Notice of Violation and Request for Withdrawal

The West Side Coalition of Neighborhood Associations (WSCONA) has received notice of an improper hearing before a City of Albuquerque Development Hearing Officer (DHO) regarding an application for “DHO Major Subdivision Action to Subdivide the subject property into 4 legal tracts.” and to “Dedicate additional right-of-way to the City of Albuquerque along the project frontage as shown and grant easements.”

Subject property: “Unassigned Addresses - 99999 VALIENTE NW (x2 lots)”

Location: “South East Corner of Paseo and Kimmick”

PASEO AND KIMMICK EAST
ALBUQUERQUE, NM
CONCEPTUAL GRADING
AND DRAINAGE PLAN

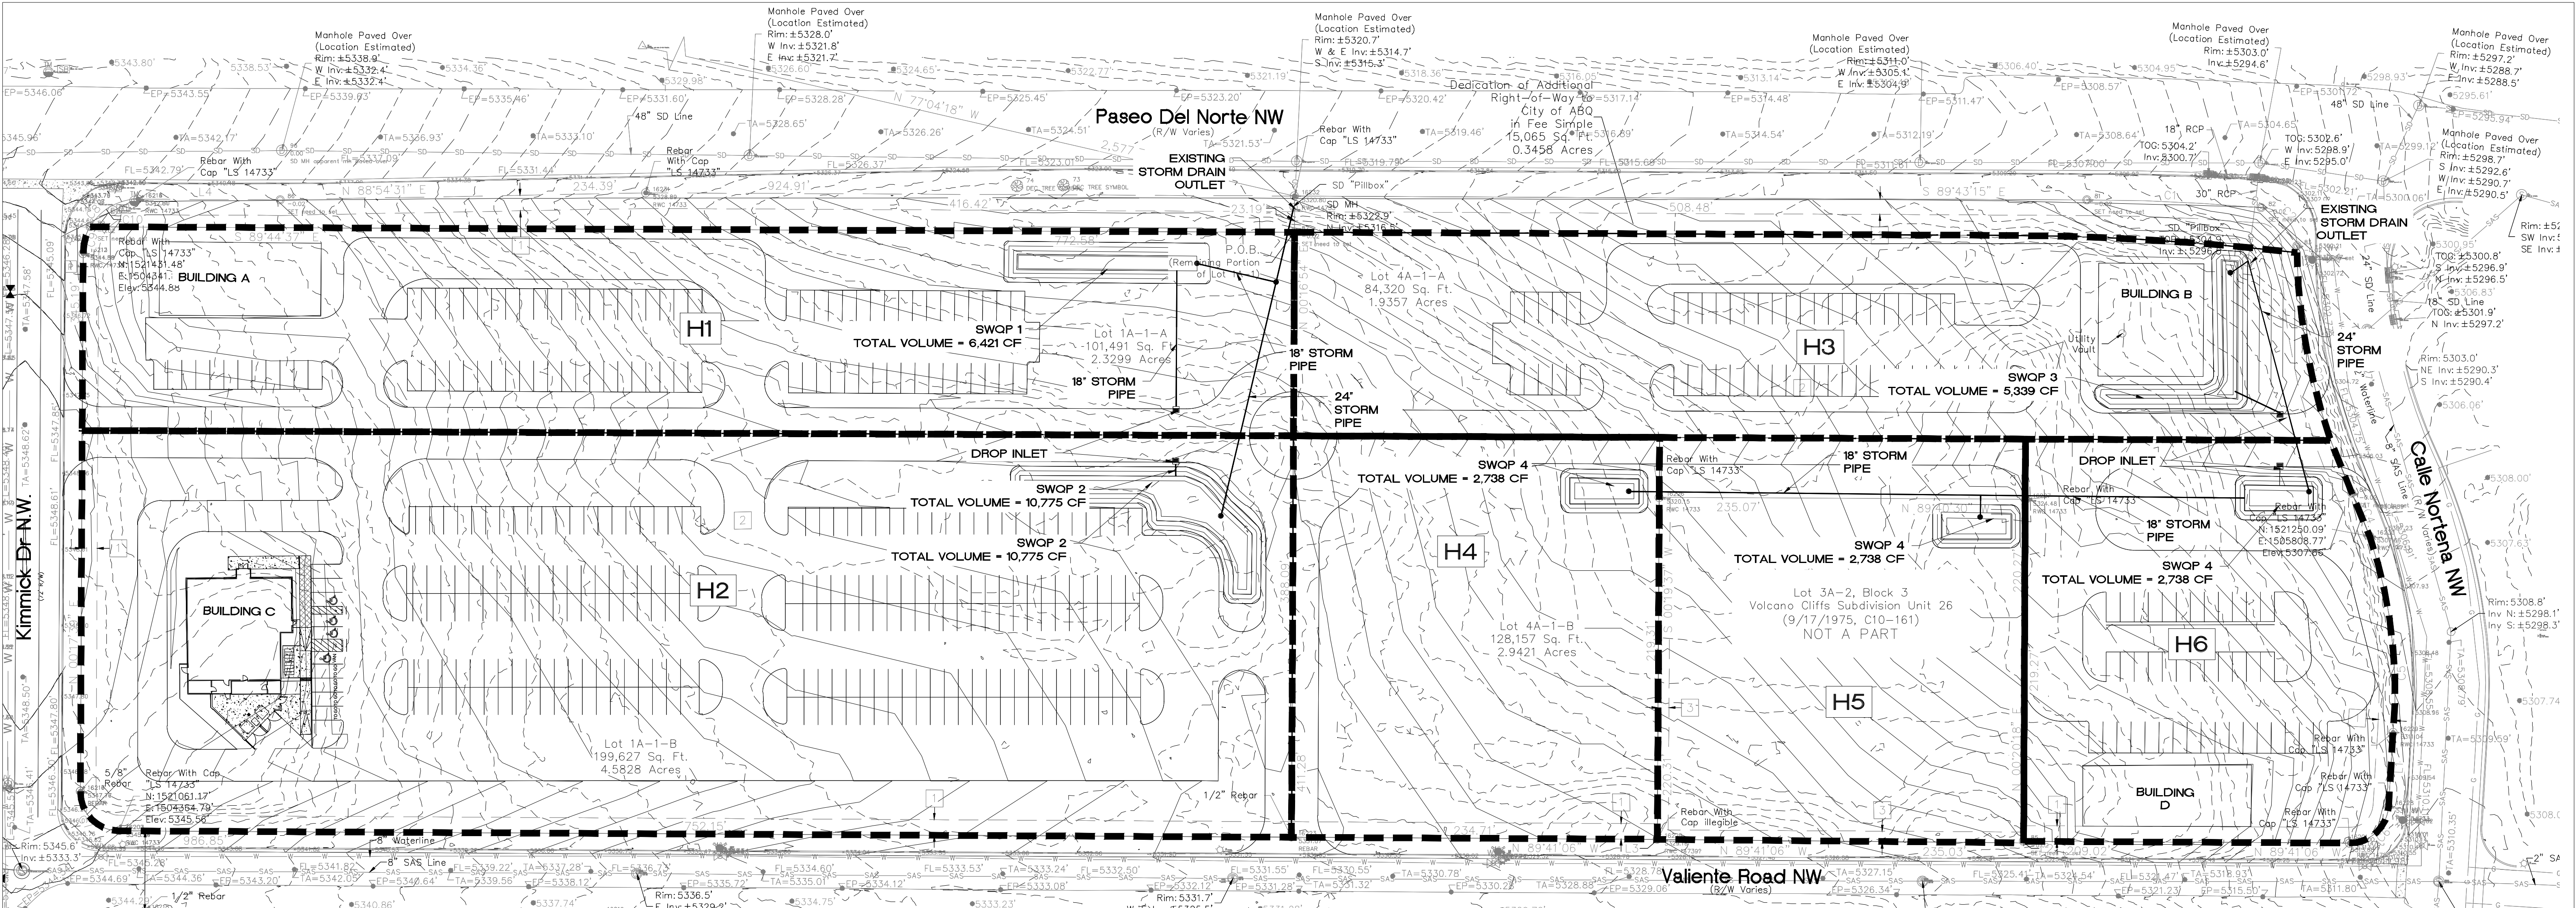
Since much of the documentation related to this request was not provided in the Notice to WSCONA from the applicant, we were not privy to what kind of development is planned for the site. Ostensibly, in the “CONCEPTUAL GRADING AND DRAINAGE PLAN” which appears to have received preliminary approval from Anthony Montoya, Jr., P.E., C.F.M. Senior Engineer, Hydrology Planning Department, Design Review Services, there appear to be multiple buildings and extensive parking lots, without specified building heights. However as a conceptual plan, this does not appear to be binding upon what would be permissive at the site after subdivision via the DHO. In order to help visualize what could be permitted, we have provided correct-to-scale models of three buildings located on the proposed southern subdivided parcel. The first building is 150 x 600 feet and 48 feet tall, with the foundation starting at current natural grade on the West-most portion of the lot. The second and third buildings are both 150 x 150 feet & 38 feet tall, also at current natural grade, which is significantly lower due to the steep slope.

Boundary Survey,
ALTA/NSPS Land Title Survey
and
Slopes Analysis
for
Portion of Lot 1A-1 and all
of Lot 4A-1, Block 3
Volcano Cliffs Unit 26
City of Albuquerque
Bernalillo County, New Mexico
July 2025

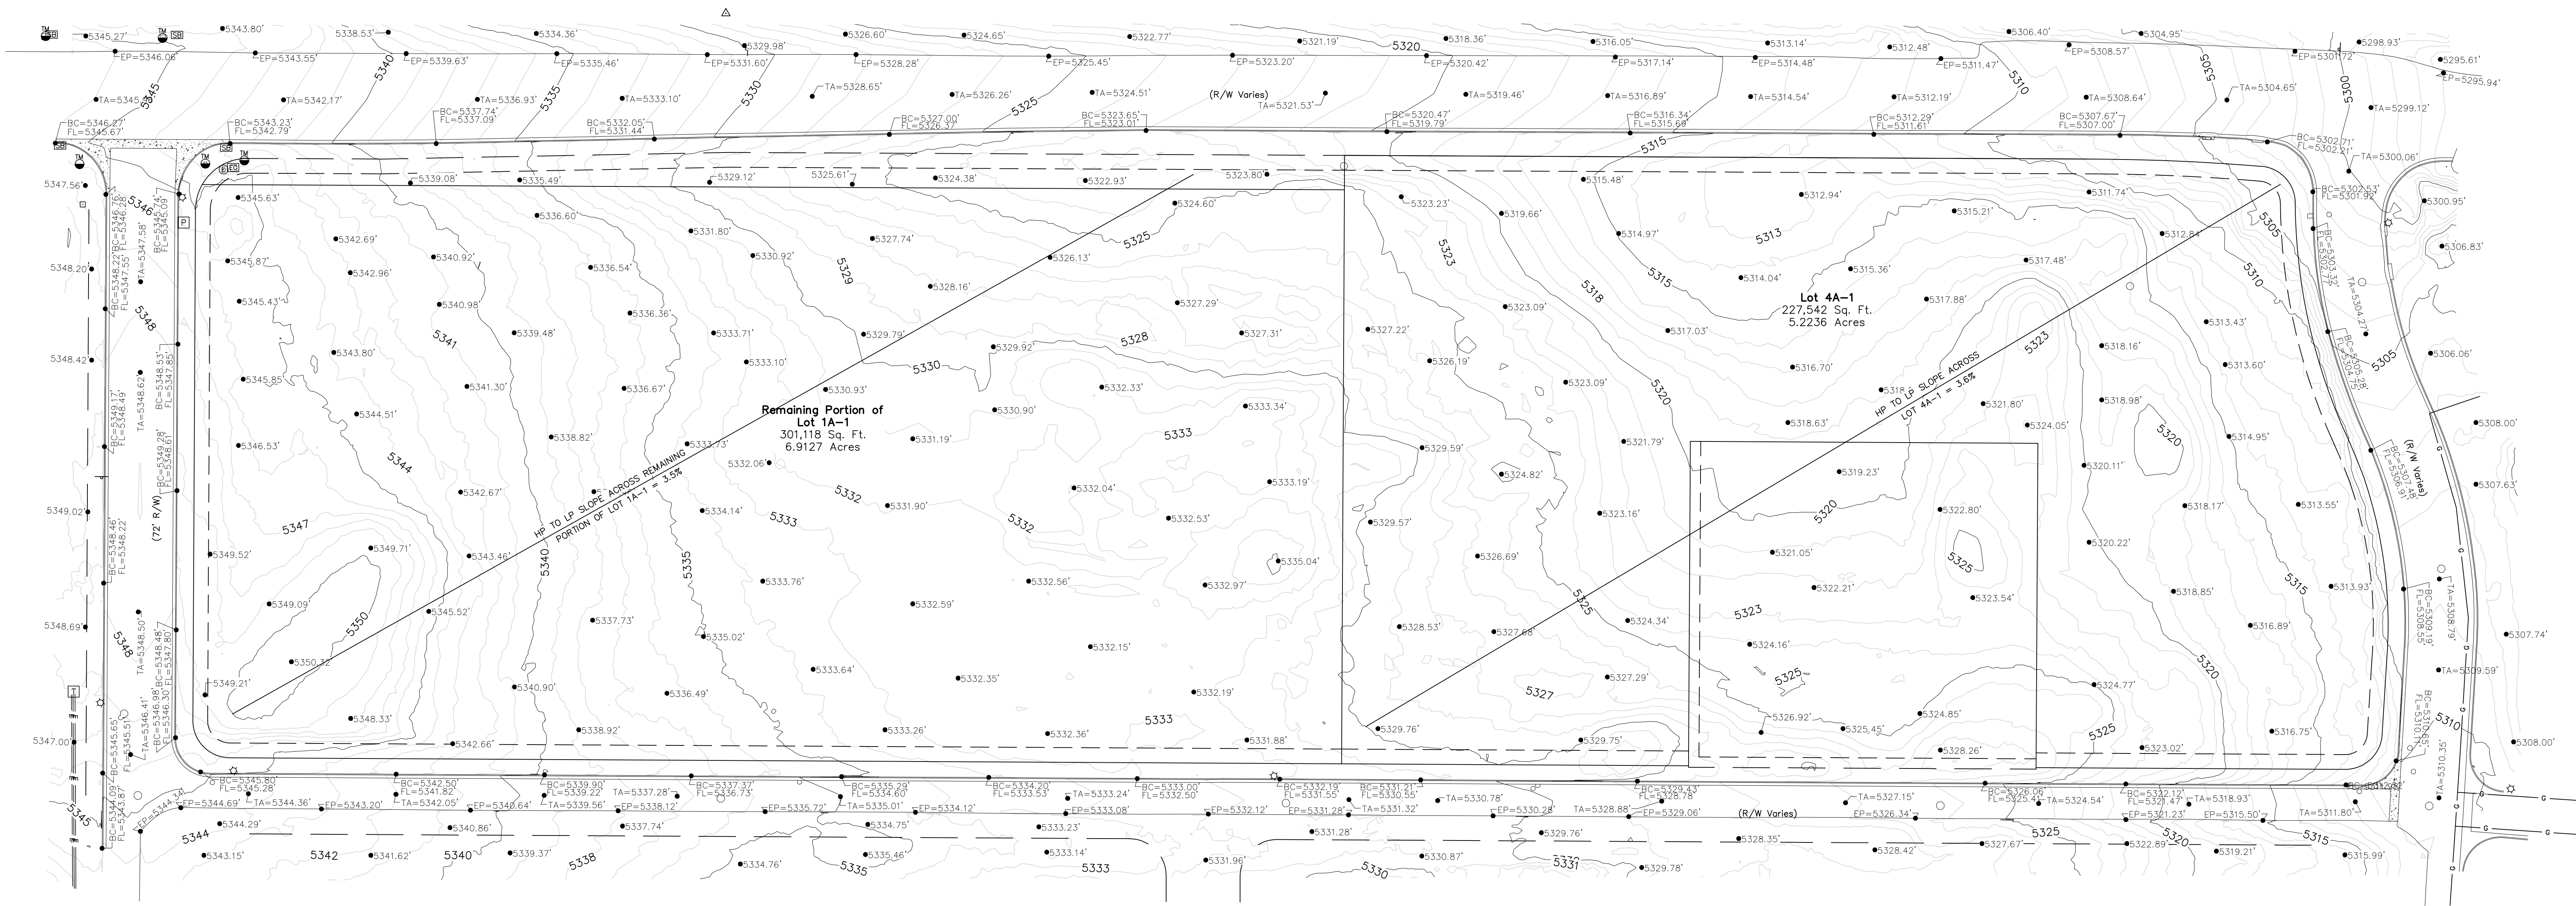
Using Google Earth Pro terrain tools, a path drawn across the Site (yellow line below) shows that the slope of the land is as high as 13.8% across that particular transect.

The Site in question clearly meets the Sensitive Lands definition of both “Escarpment” and “Steep Slope”, and therefore must be processed as a Site Plan – EPC.

Purpose of Plat

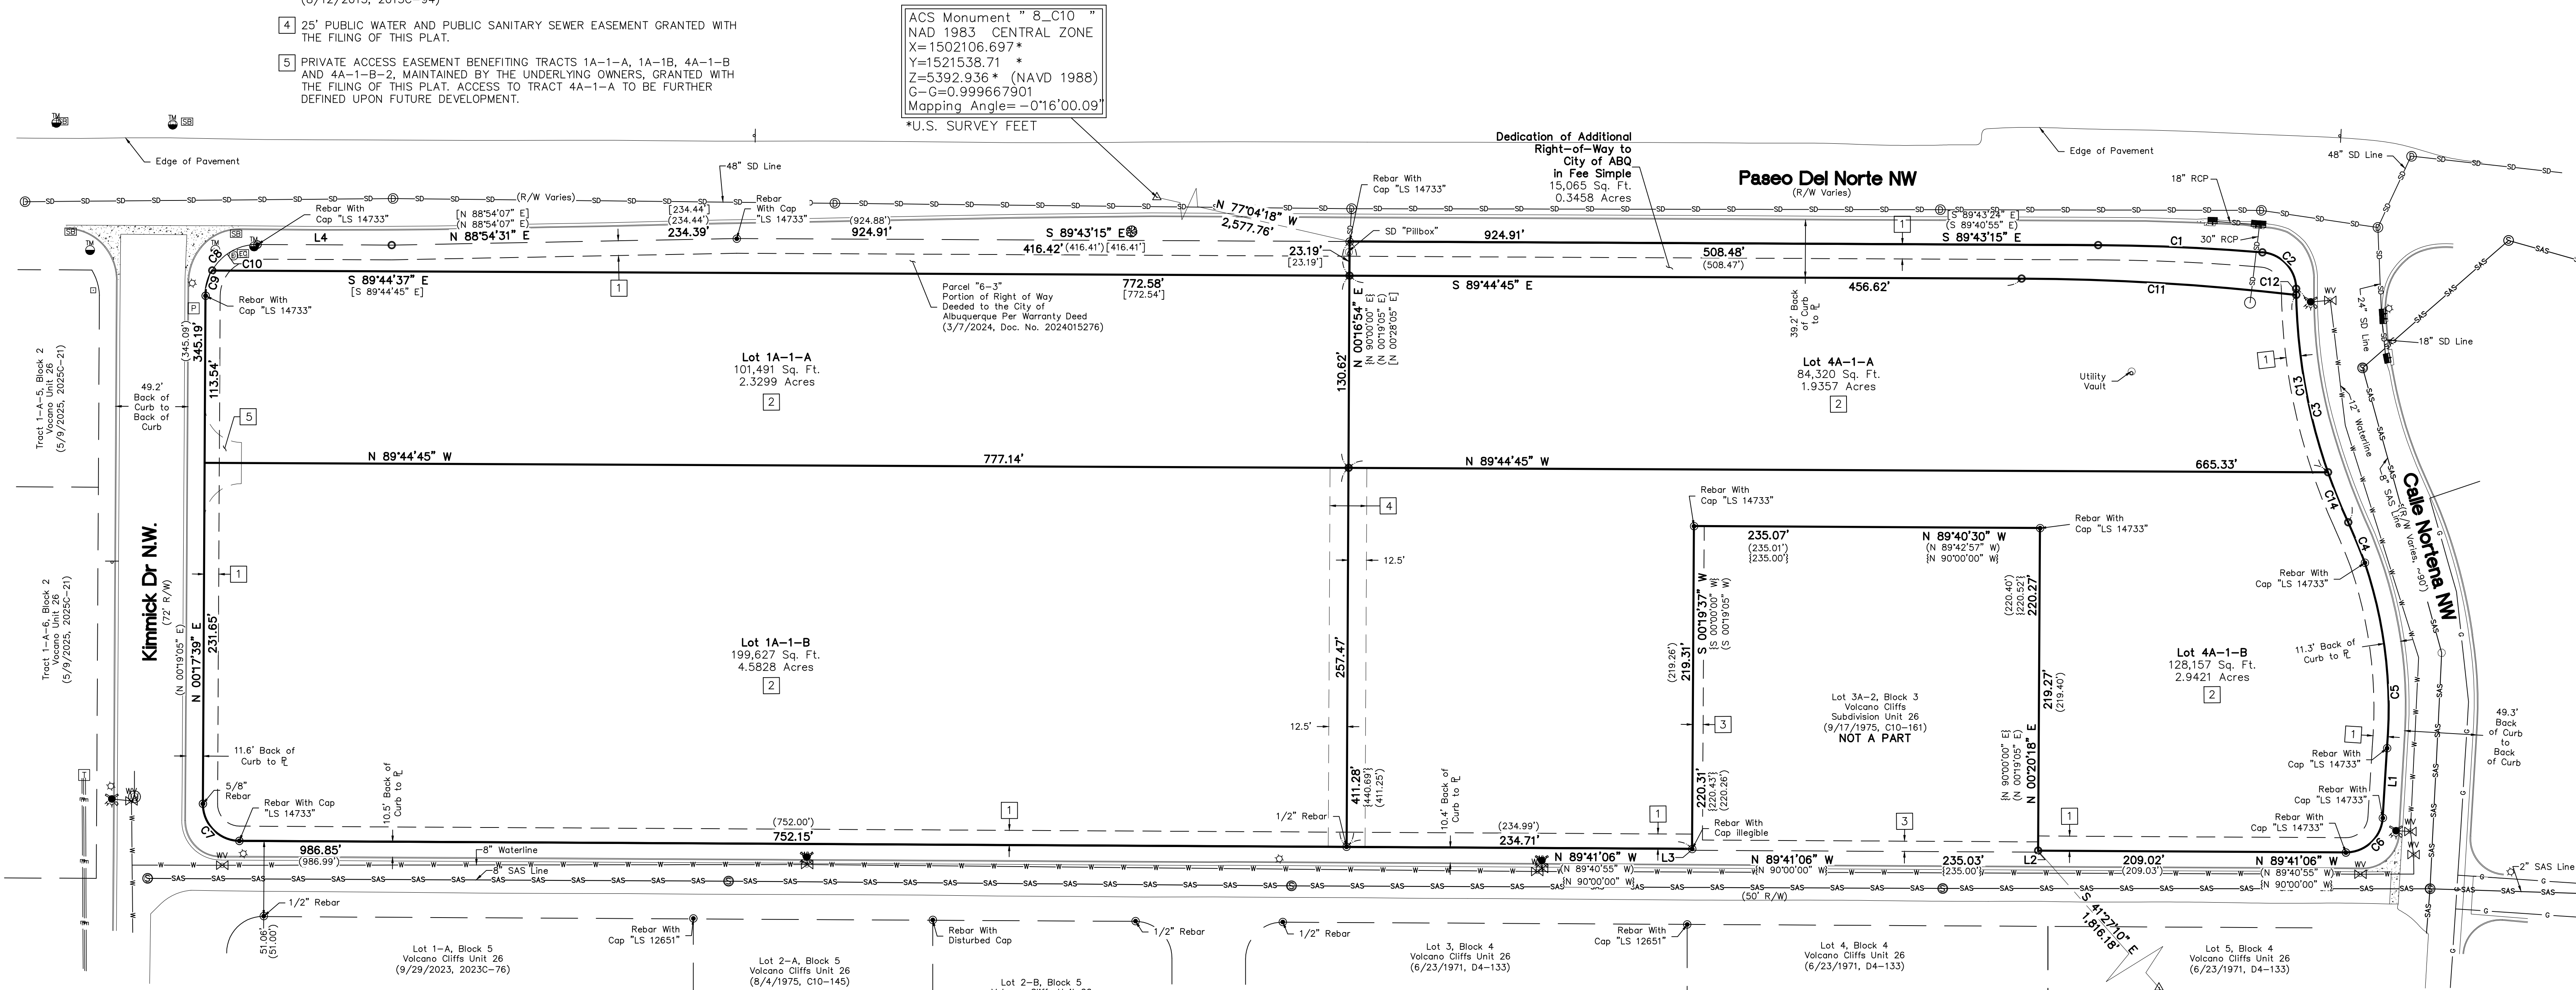
Due to the location of this property on and near sensitive lands, the DHO does not have the authority to hear such an application, and any such request for subdivision must first seek approval for a Site Plan — EPC before the Environmental Planning Commission under 14-16-6-6(l)(1)(c)(4) and 14-16-5-2(C).

In the second map, the parcels are subdivided as per the request, with the apparent intent to create two parcels with maximum building heights of 48' (red) and 38' (orange) respectively.

Placing 48' tall structures at that location (which occupies the highest elevation of the parcels in question) would directly conflict with the purpose of the VPO-2 and goals of the

Thus to avoid years of similar litigation, the Application should be withdrawn or the acceptance of the Application for hearing before the DHO should be revoked, and the Applicants directed toward submitting a Site Plan — EPC instead. It should be noted that under such a Site Plan—EPC, compliance with overlay zones, such as the VPO-2 Height Restriction is required for the entire Site covered by the plan and is not discretionary. Thus, the plan should be for single story neighborhood-scale businesses at this location.

Figure 1: Aerial of Site and Vicinity.

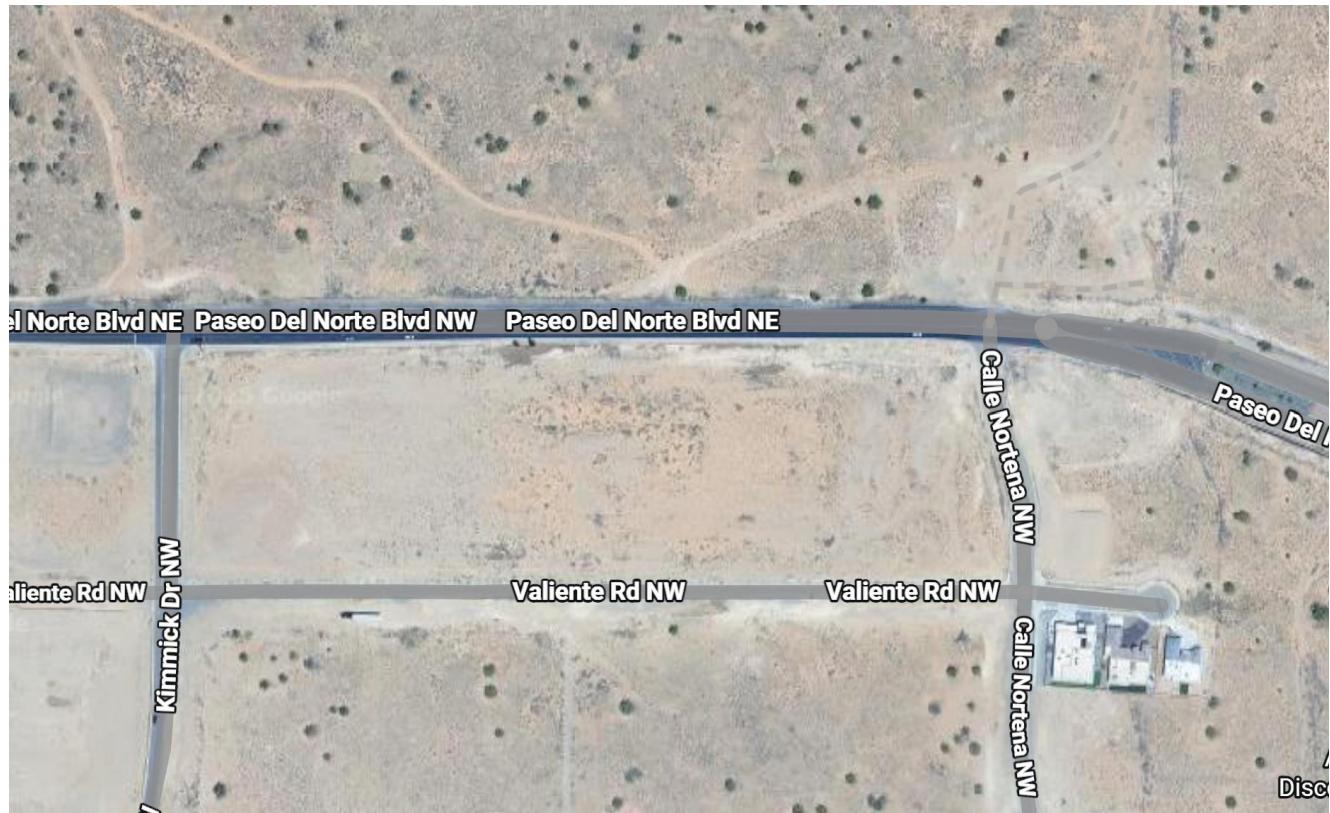
A “Sensitive Lands Analysis”—Dated October 15, 2025—was apparently submitted by the Agent, however, as can be seen in the map that was included by the Agent and reproduced below (map in red box), the Agent shows a different location as the identified “SITE” and clips off the entire northern portion of the actual site, concealing the presence of the VPO-2 Height Restriction Sub-Area or the site’s location at the crest of Paseo del Norte after rising through the escarpment and its technical adjacency to PETR.
